Re: Response to Colorado Geological Survey Review
Sterling Ranch Filing No. 5
Parcel 16
El Paso County, Colorado

Ref: Entech Engineering, Inc., dated November 22, 2022. *Soil, Geology, and Geologic Hazard Study, Sterling Ranch Filing No. 5, Parcel 16, El Paso County, Colorado.* Entech Job No. 222159

CGS COMMENTS AND ENTECH ENGINEERING, INC. RESPONSES

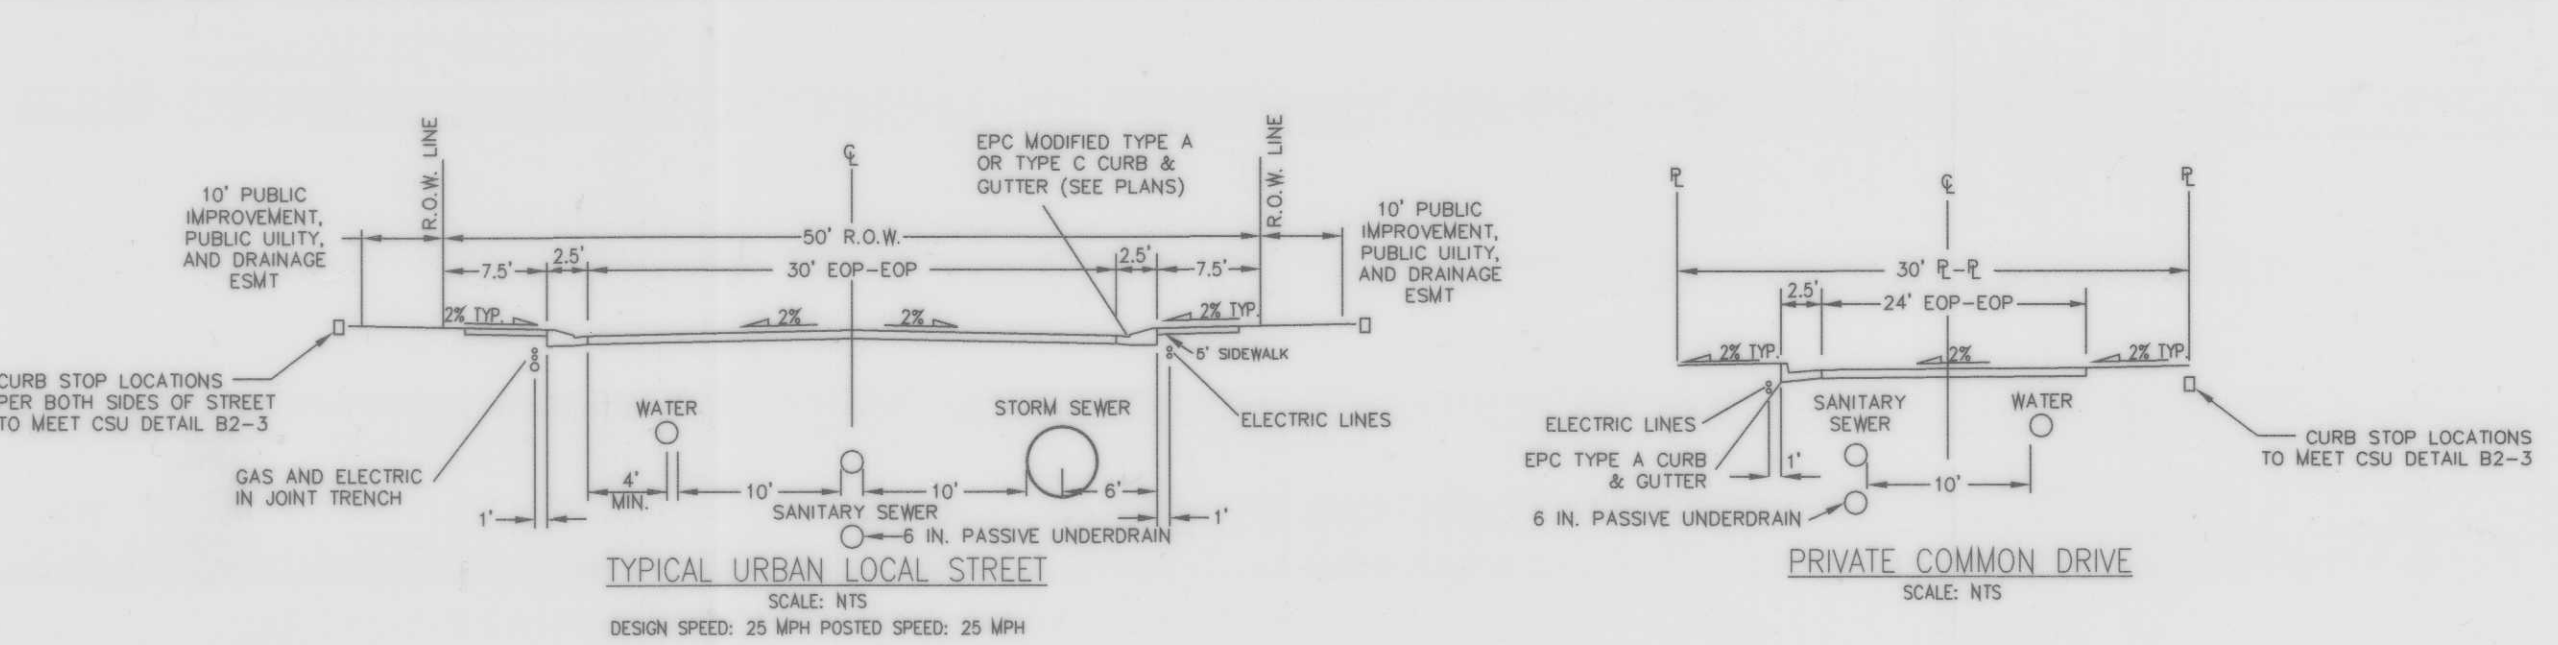
CGS Comment: *“Groundwater was encountered at depths of 16 and 18.5 feet in Entech’s borings during drilling operations in the fall of 2022. If basements are being considered and based on our experience in the Sterling Ranch development, CGS recommends the County require groundwater monitoring/observation to obtain groundwater data to verify that proposed floor elevations are at least 3 feet (preferably 5 feet) above maximum anticipated groundwater levels and maintained year-round. This monitoring/observation program should be conducted to determine the feasibility of basements and if an underdrain system is required due to shallow groundwater conditions. To be effective, however, this monitoring should include measurements/observations through fall, winter, and spring and not merely during site specific building investigations.”*

“Subsurface perimeter drains may be necessary to prevent the intrusion of water into areas below grade. Additionally, where shallow groundwater is encountered, underslab drains or interceptor drains may be necessary,” and “Where basements are considered, interceptor and underslab drains may be necessary.” Mitigation measures recommended by Entech should be included in the preliminary plan.”

Entech Response: As mentioned above shallow groundwater is not expected to be an issue given the data from the test borings drill on the site. Additional site investigation will be conducted as development plans are being prepared, and following completion of site grading. Drainage improvements along roads and utility underdrains will intercept potential shallow groundwater. In our opinion, the site can be developed based on the preliminary plan. Adjustments to grades and/or type of construction (basement/crawlspace) should be evaluated as plans are developed. Basement feasibility should be evaluated on a block by block basis pending the results of additional site investigation and approved grading plans.
